14 June 2017

Ms Nikki Matthews
Department of Planning & Environment

Notice of Exhibition of Toxfree Chemical Waste Storage and Treatment Facility at 40 Christie Street, St Marys (MP06_0095 MOD 4)

Figure 5.6.1; Proposed Weighbridge, loading and unloading operations & internal traffic flows.

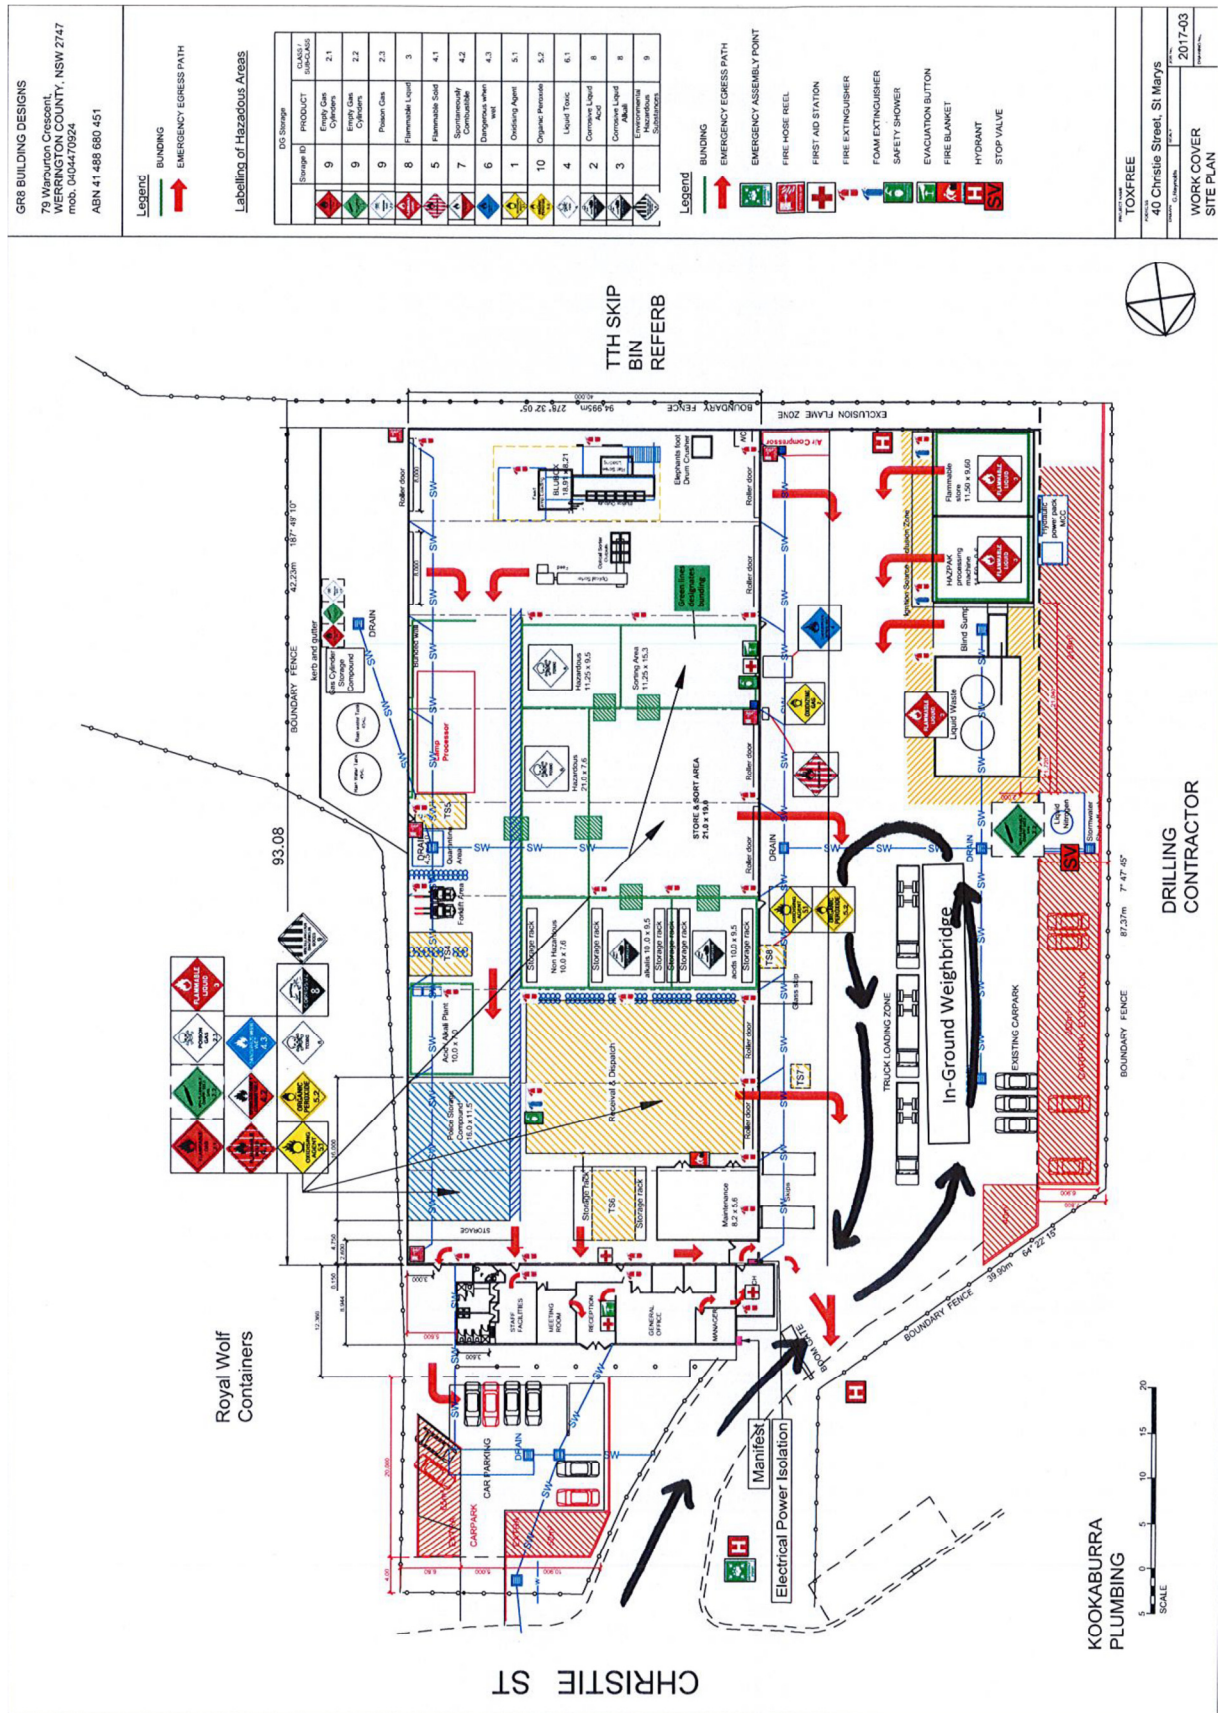
- It is not clear what the “extra extension” on the plans is intended to be used for. The areas noted as 52m², a 40m² and a 215m² should be clarified. It is also not clear whether the existing carpark will be removed or if it is to remain. If it will remain, the stacked car parking should be employee parking only;
- Full dimensions of all proposed parking areas should be provided to ensure the spaces comply with the Australian Standards;
- The proposed 5m wide driveway for general customer parking in front of the office is not suitable. A 5.5m wide driveway is required to be provided for two-way movements; and
- Swept path diagrams have not been provided demonstrating that the design vehicle can traverse the site in accordance with AS2890.1 ‘Parking facilities Part 1: Off-street car parking’.

PLAN SCALE 1:20  
PIT TYPE FLOW CONTROL PIT

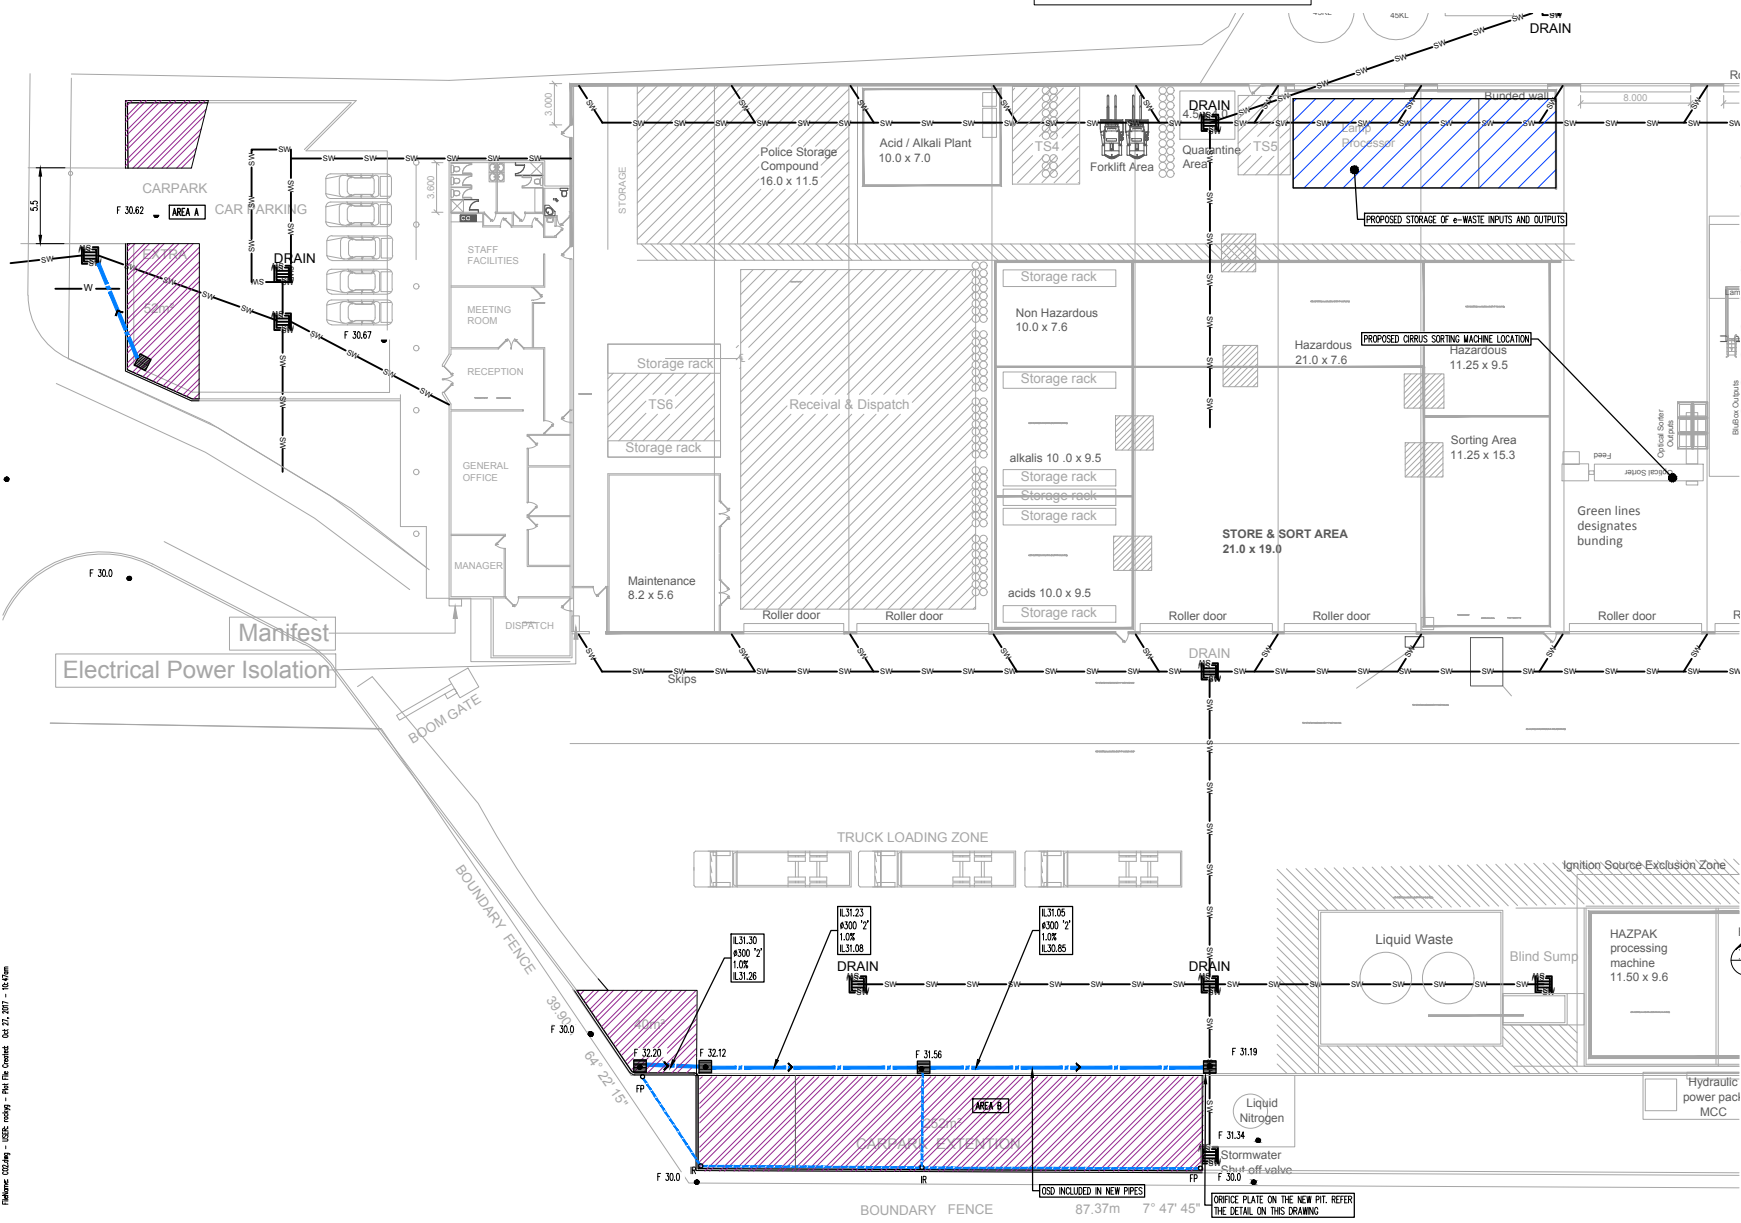
A stormwater drainage plan is to be provided to address the proposed impervious areas with finished surface levels along the western property boundary. If stormwater generated from those areas won't be able to discharge to the existing drainage system, then stormwater drainage pipes shall be provided. The required stormwater drainage plan shall also consider WSUD and OSD requirements.

Water Sensitive Urban Design (WSUD) is required for the proposed carpark and impervious areas along the western property boundary (total areas > 250m²). The applicant should also address Council's WSUD Policy and Technical Guidelines.

According to Council's Stormwater Drainage Specification for Building Development, a stormwater On-Site Detention (OSD) is required to be provided, if there is no existing OSD. This needs to be confirmed and addressed.
